Submission No.			066	
Organisation Name or Name of Submitter			District 7 Community Alliance (An alliance of 7 resident associations in North Central Dublin around the Mater Station)

Item No.	Section Ref.	Page No.	Observation Statement	TII Response
Letter Re: Railway (Metrolink-Estuary to Charlemont via Dublin Airport) Order 2022				
1	Letter	1 and 2	<p>As a community, we welcome the development of the MetroLink project which will bring benefits to our community, to Dublin and to the country as a whole and look forward to its timely delivery.</p> <p>We do, however, have concerns in relation to the proposed works as they affect our community. These are outlined in detail in the enclosed submission, but we would like to draw attention to three key concerns.</p> <p>In order to keep local residents informed of developments and ensure buy-in and support from the community, we request the establishment of a Mater Station Liaison Committee to ensure continuous communication and consultation with local residents before, during and after the construction phase to address concerns in advance of proposed works and also as particular issues arise.</p> <p>The Liaison Committee should also allo

MATER STATION

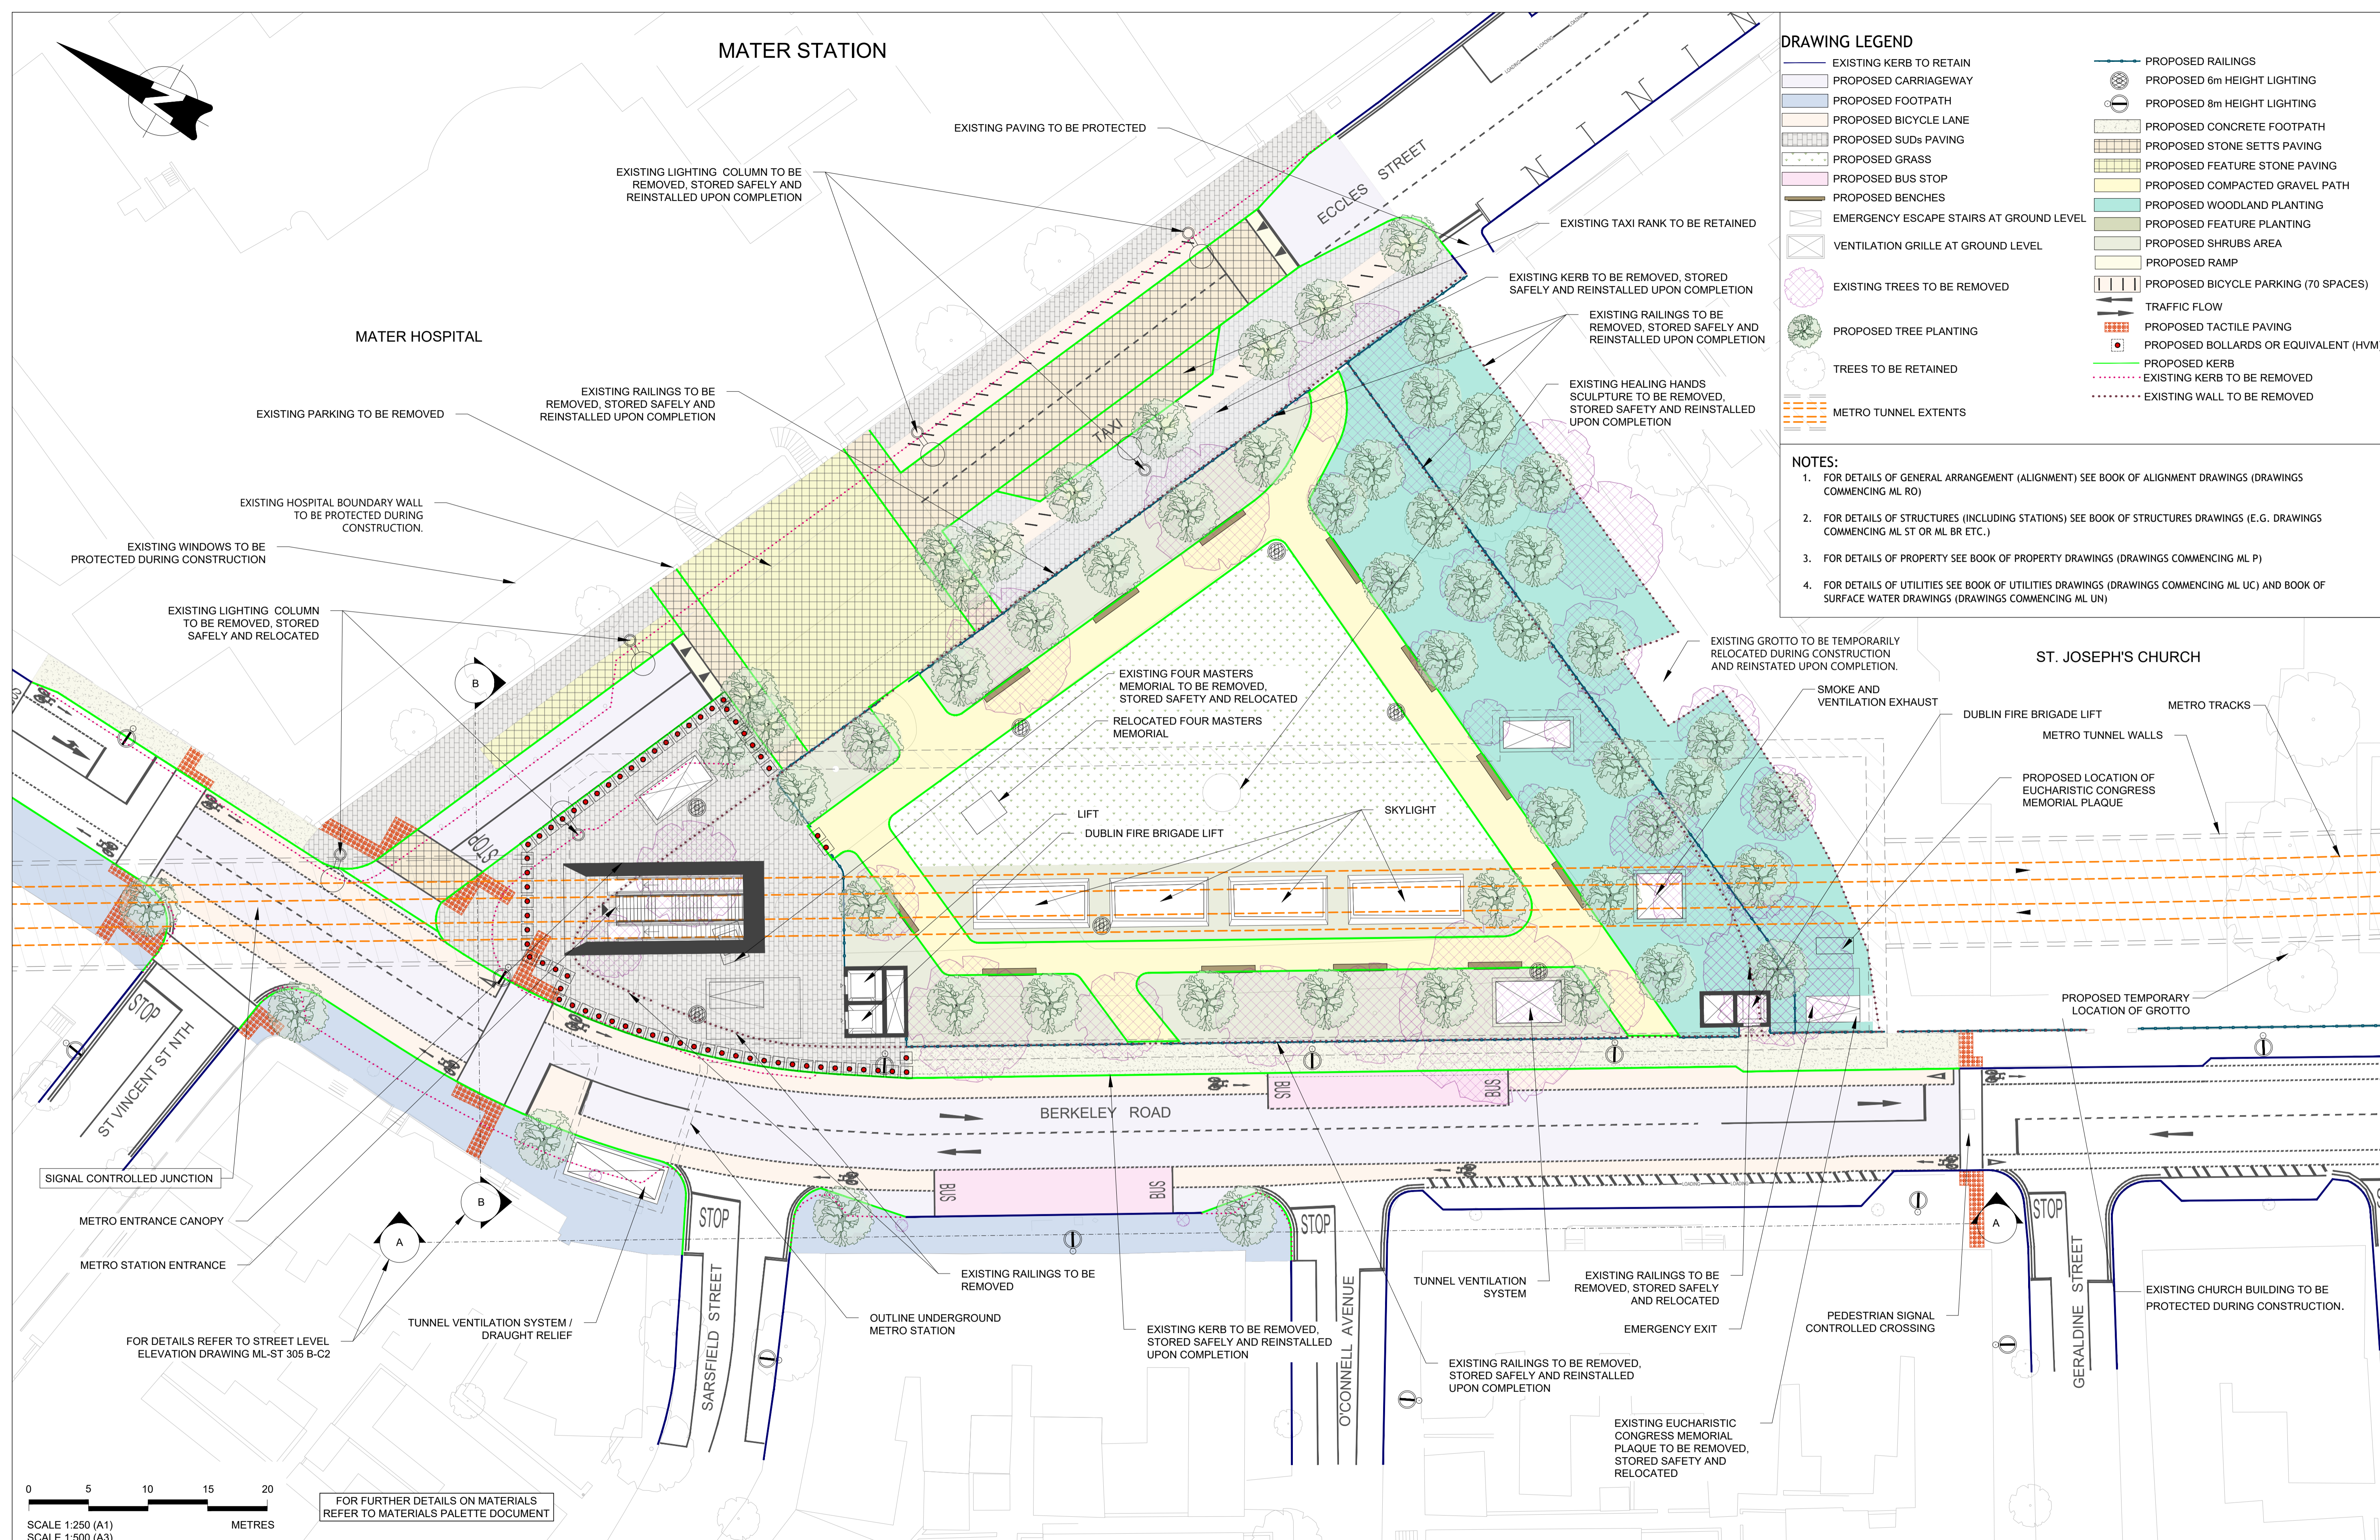
2	Letter	2	<p>The local community is unanimous in its view that the design of the station is out of character with the surrounding architecture and also wishes to have the Four Master Park restored as far as possible to its original appearance. To that end, we request local input into these proposals through the Mater Station Liaison Committee.</p>	<p>As noted in response item (1) above, TII are committed to engaging with and listening to the views and concerns of the District 7 Community Alliance, and working with the community to manage any impacts resulting from MetroLink construction.</p> <p>Prior to the submission of the Railway Order Application, TII engaged with the local business community and explained the sequencing of works and environmental impacts as set out in the Railway Order submission. TII are committed to addressing the concerns of the local business community that are detailed in the District 7 Community Alliance submission and to continue to address their concerns throughout the projects construction stage through one on one engagement and through the soon to be established local business forum.</p> <p>Please refer to response items (11, 12 & 13) below in relation to the architectural design of Mater Station.</p>

14	3 - Observations - 3.1.1 Design Observations	11	<p>The removal of 50 mature trees from this relatively small area is excessive, unnecessary, at odds with Government climate action and biodiversity policy, and would represent a significant environmental and visual amenity loss to the local area.</p> <p>The Planning Report states that “<i>tree planting will ...be relatively immature and will not enclose the Park or contribute much to the definition of the two adjoining streets for at least a period of approximately 7-10 years</i>”.</p> <p>In light of this, proper consideration should be given to protecting existing mature trees where possible, as well as reinstating mature trees that must be felled with mature specimens.</p> <p>We do not believe that there are any technical barriers or difficulties preventing consideration of the above matters which will in turn result in the nearly full reinstatement of the Four Masters Park, its environs and the vistas to and from local protected structures after construction and ask that local residents, for whom views are an amenity of their property (and who have not had access to any studies of the visual impact assessment), be consulted on the above aspects.</p>	<p>EIAR Chapter 27 (Landscape) details the impact on the landscape and visual amenity of the stations during both the construction and operational phases. On completion of the station box, the existing Four Master Park and its surface features will be substantially reinstated with the visual amenity of the area largely restored, much to its existing condition and improved in respect of the shared space to the front of the original hospital building, the refinement of the park layout and the tree and plant species selection.</p> <p>Over the initial period after completion of the construction, the maturity and ambience created by the existing trees cannot be matched. However, as the new trees mature, this too will return with views along the adjacent streets and into the Park, much as they were. The restoration of the open green park space within the triangle of buildings along with the proposed amendments to the original Mater Hospital section of Eccles Street, will again impart the tranquil qualities of the existing condition.</p>

Item No.	Section Ref.	Page No.	Observation Statement	TII Response
Letter Re: Railway (Metrolink-Estuary to Charlemont via Dublin Airport) Order 2022				
15	3 - Observations - 3.1.1 Design Observations	12	<p>There are many examples of modern underground stations with a much smaller elevation, visual impact and footprint above ground. Other similar projects have also incorporated design contests for station canopies to promote local acceptance.</p> <p>Examples given:</p> <ul style="list-style-type: none">- St. Cathedral Parkway Subway Station by LHP Architects - New York.- Compact metro canopy designs - Bilbao	<p>The station architecture is integrated in the park in a sympathetic fashion with the skylights being framed by planting and providing circulation routes through the park. Existing monuments and protected railings will be relocated within the park. Large mature trees will be placed so as to provide balance and create space within the park. The landscape design itself will be created on top of the station box and sufficient depths and infrastructure are provided for in order to integrate the landscape design.</p> <p>TII believe that the commissioning of internationally renowned architect Nicholas Grimshaw and Partners, has delivered a contemporary station design which is appropriate for a state of the art metro system such as MetroLink. Appropriately, significant emphasis is placed on the public spaces. The station concourse at Mater will be a soaring space illuminated from above with natural light. Dublin's rich architectural heritage has been respected, but not copied in a pastiche imitation. In accordance with best conservation principles, as set out in the ICOMOS Venice Charter of 1964, the stations are architecturally distinguishable so as not to falsify the existing historic context. Reference and due respect to that context is made through the choice of high quality and appropriate materials and the scale of the interventions.</p> <p>At Mater station, the canopy entrance evokes the scale of park structures. The aesthetic values of all eras, including our own, have cultural validity, and therefore the brick is used in a contemporary way reflecting contemporary aesthetic idioms derived from 21st century technology.</p> <p>TII believe the current station and surface level designs greatly enhance the public realm at all locations along the MetroLink route. There is a unifying commonality in the design of all stations, providing a consistent and coherent architectural language, which assists with orientation and wayfinding, and contributes a new architectural lexicon to the cultural iconography of the city.</p>
